# City of Portland, Maine - Building or Use Permit Application

Job No: <b>2011-07-1712-ALTCOMM</b>	Date Applied: <b>7/15/2011</b>	CBL: <b>129 - - G - 011 - 001 - - - - -</b>	
Location of Construction: <b>17 CODMAN ST</b>	Owner Name: <b>CHEUNGLUI YEE</b>	Owner Address: <b>17 CODMAN ST PORTLAND, ME 04103</b>	Phone: <b>207-879-7600</b>
Business Name:	Contractor Name: <b>Therhault, John</b>	Contractor Address: <b>22 Hawthorn ST Portland ME 04103</b>	Phone: <b>(207) 615-1799</b>
Lessee/Buyer's Name:	Phone:	Permit Type: <b>Building</b>	Zone: <b>R-3</b>
Past Use: <b>Three family</b>	Proposed Use: <b>Same – Three family – interior renovations, rebuild back deck (12’5” x 19’) w/landing &amp; stairs, rebuild basement entry, install hot tub with deck (15’5” x 15’5”) &amp; stairs</b>	Cost of Work: <b>130000.00</b>	CEO District:
		Fire Dept: <input type="checkbox"/> Approved <input type="checkbox"/> Denied <input checked="" type="checkbox"/> N/A	Inspection: Use Group: <b>R-2</b> Type: <b>SB</b> <b>IBC 09</b>

Proposed Project Description: <b>Remodel existing 3 unit apartment, chsnge rear deck, install hot tub with deck</b>		Pedestrian Activities District (P.A.D.)	
Signature:		Signature:

**A-1.0**

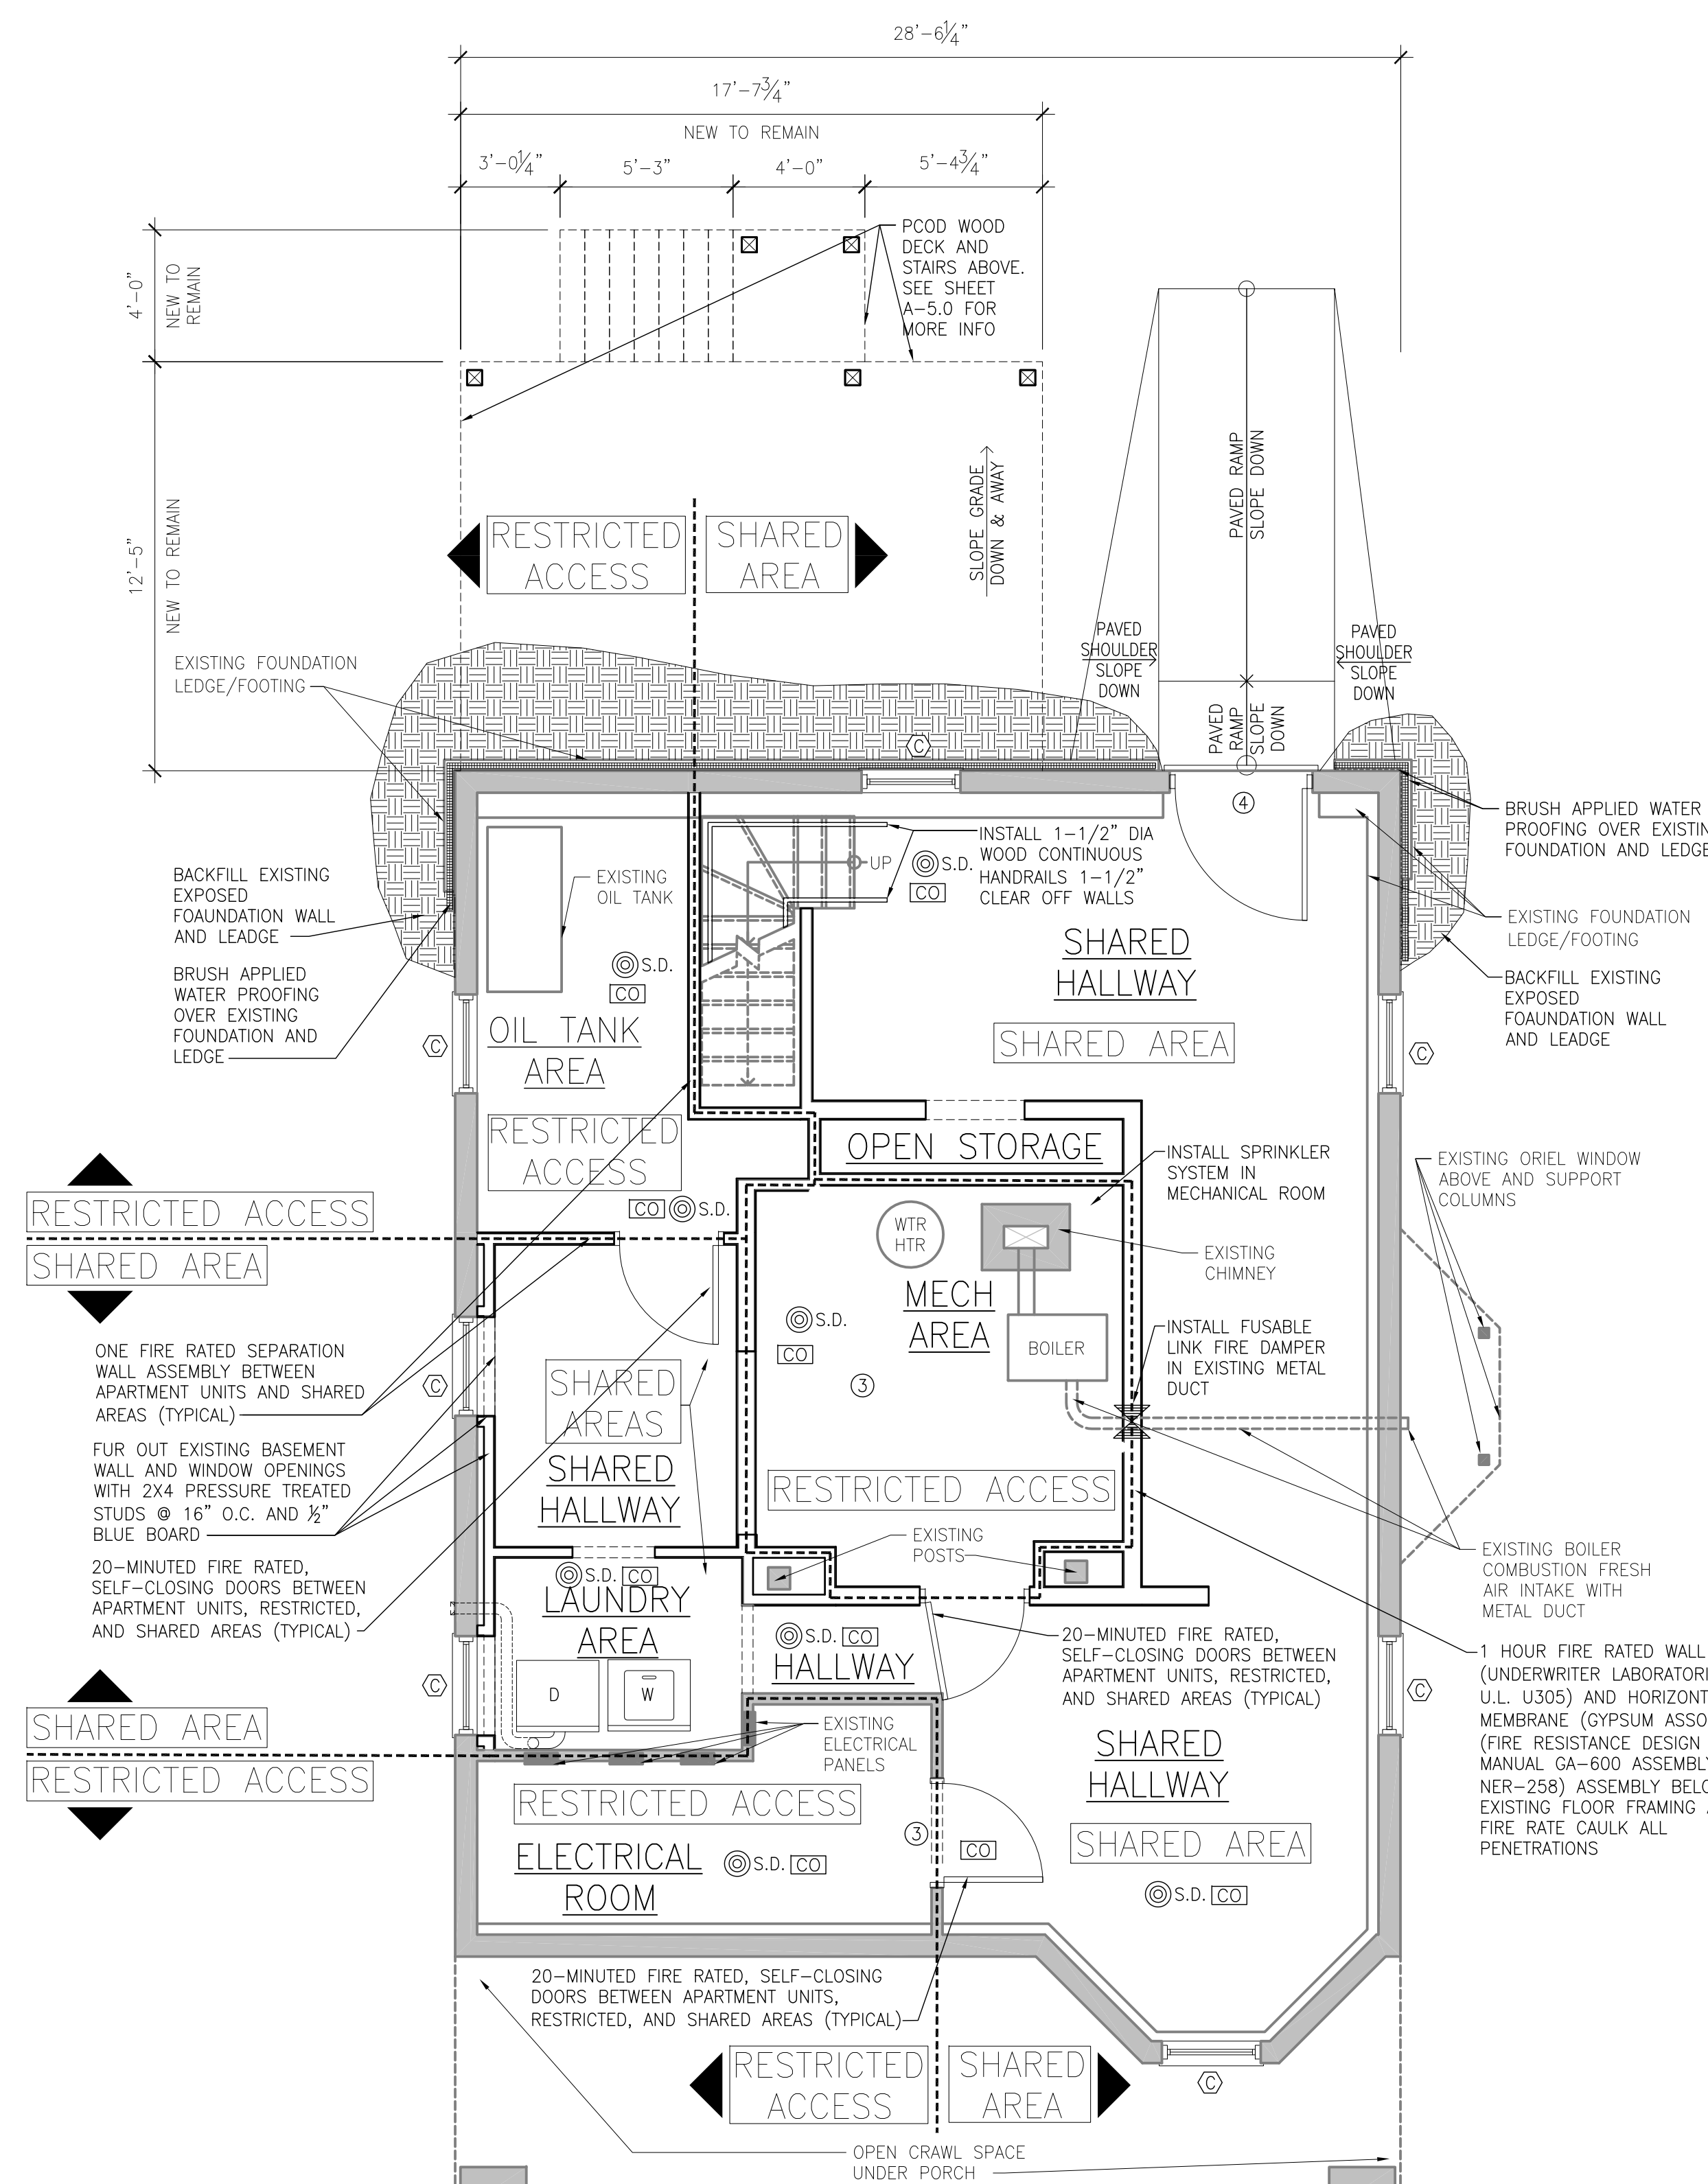
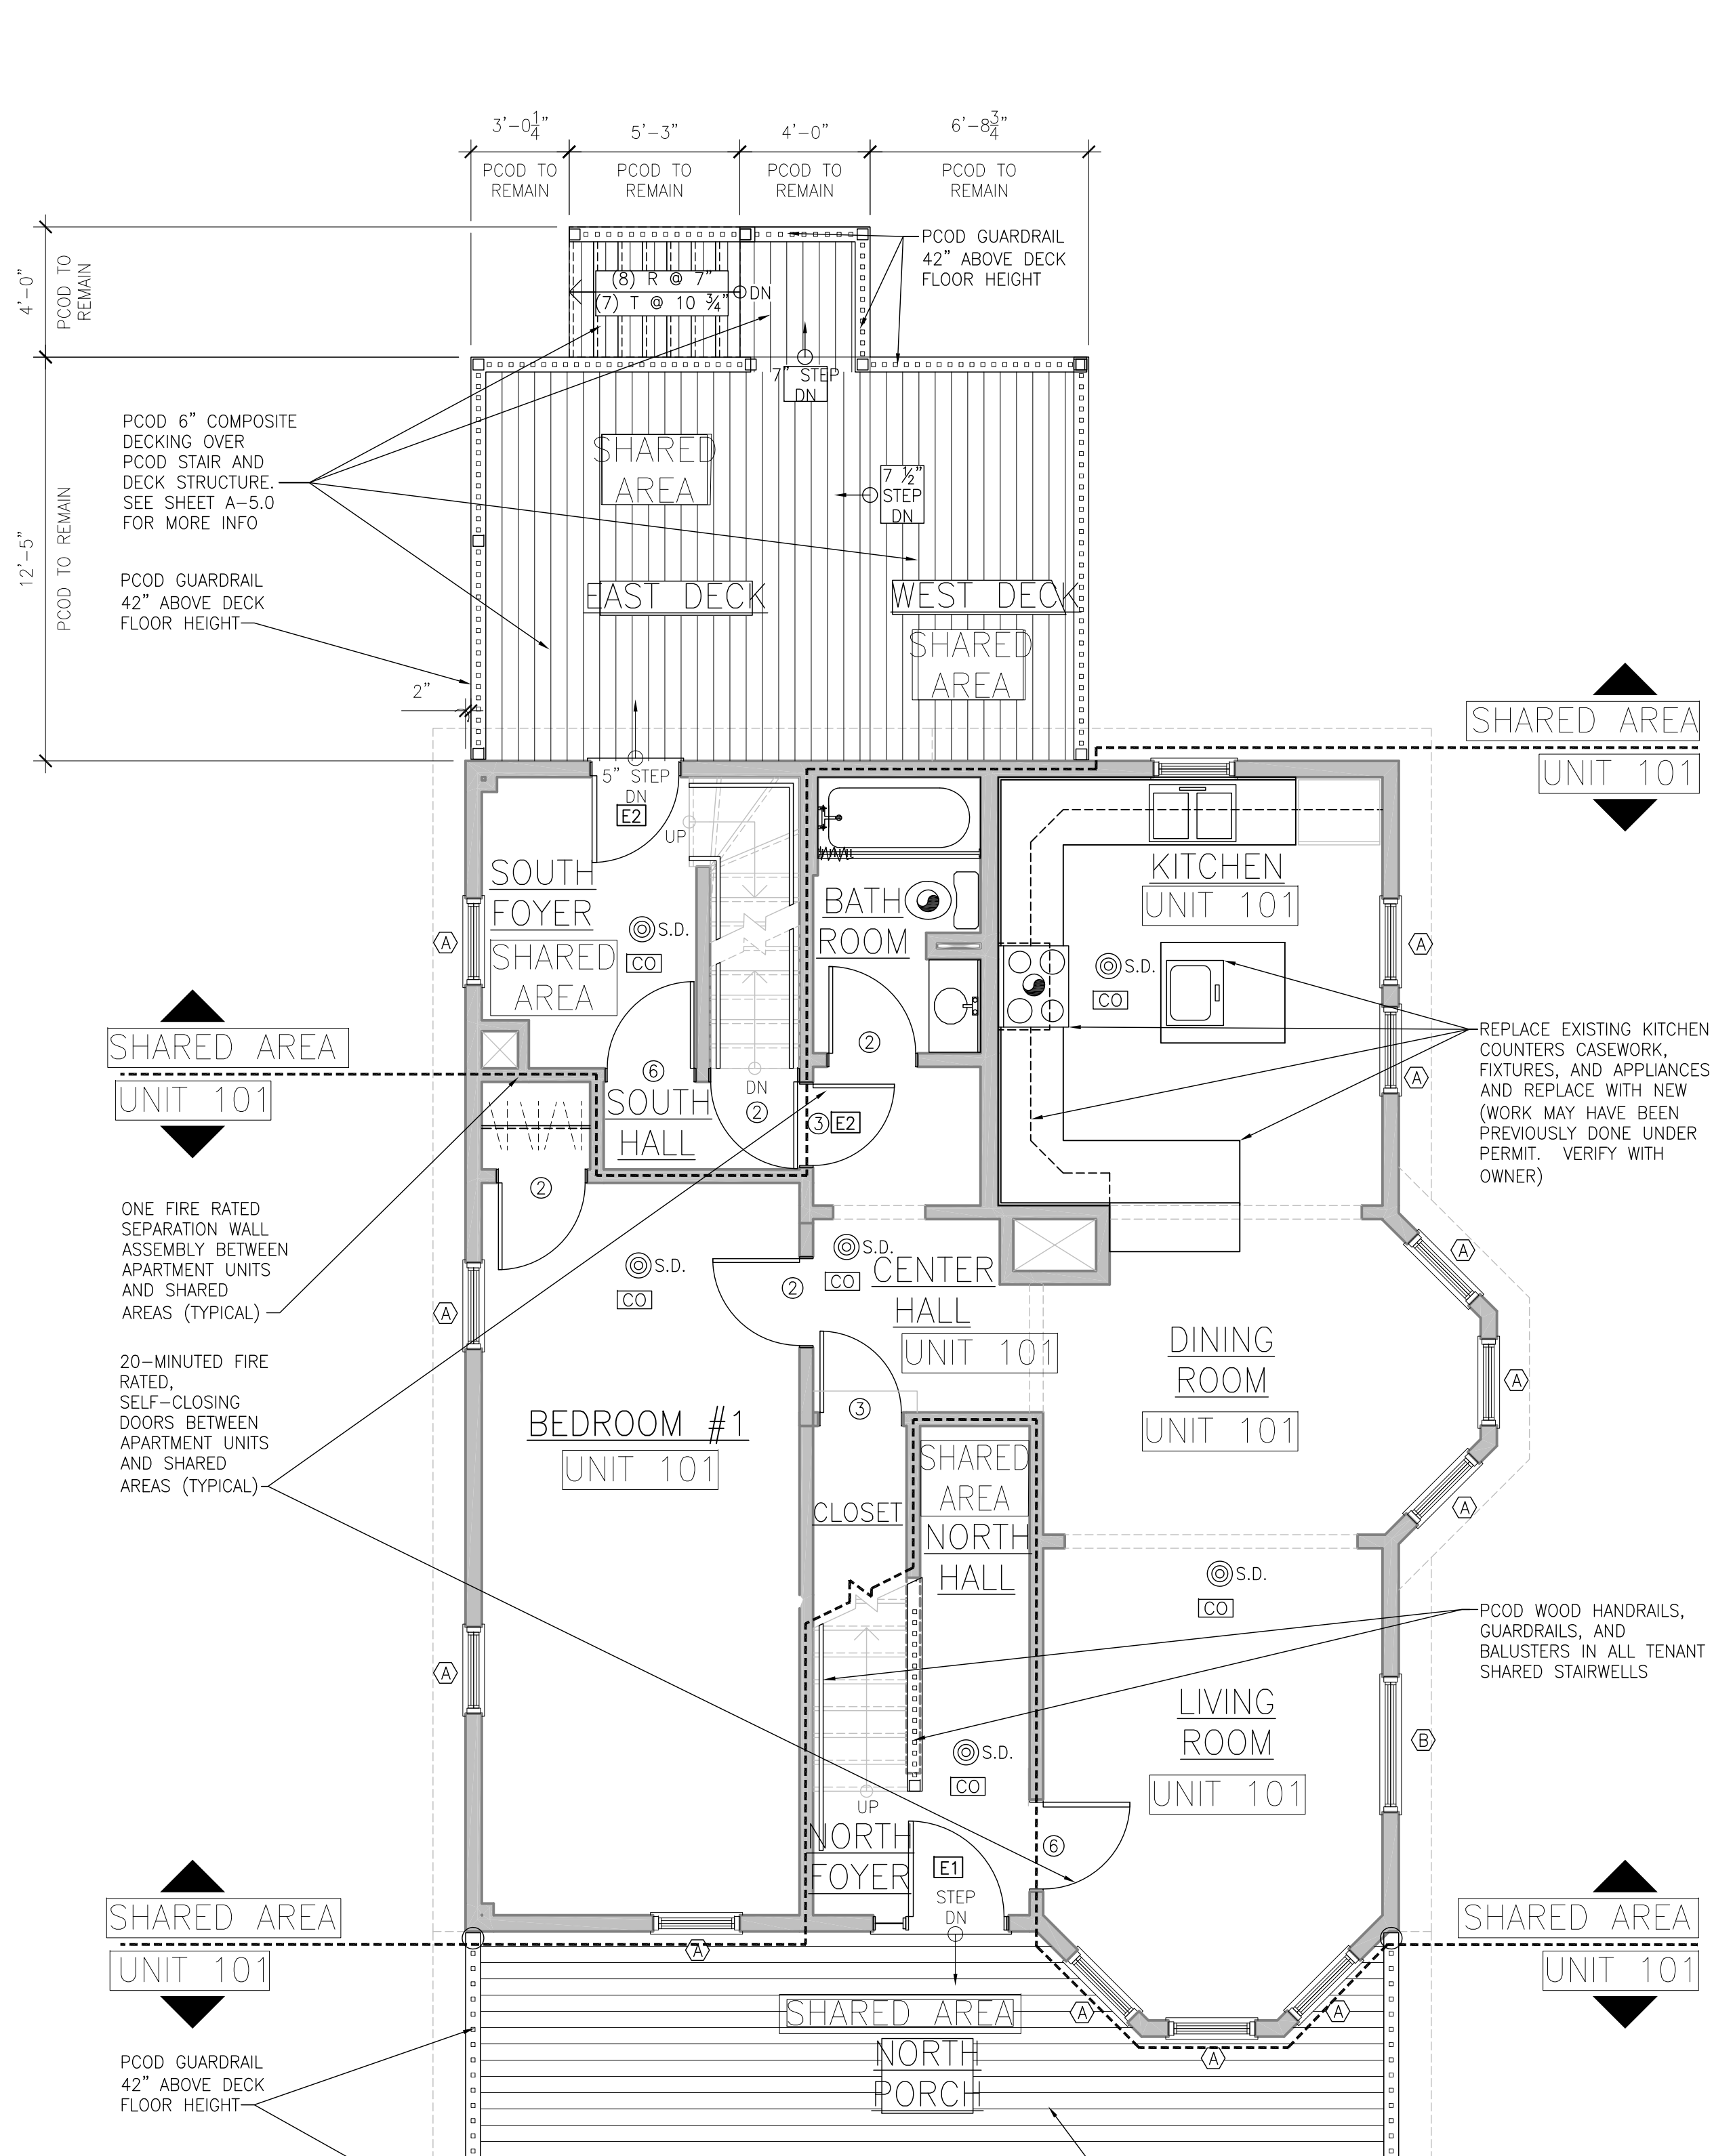
A-1.0  
Treads @ 10 3/4" - A.S  
Need 11" → Shows 11" + 7/8" w/prosiding  
Halls - common areas  
1 hour?  
Hot tub stairs - 11"
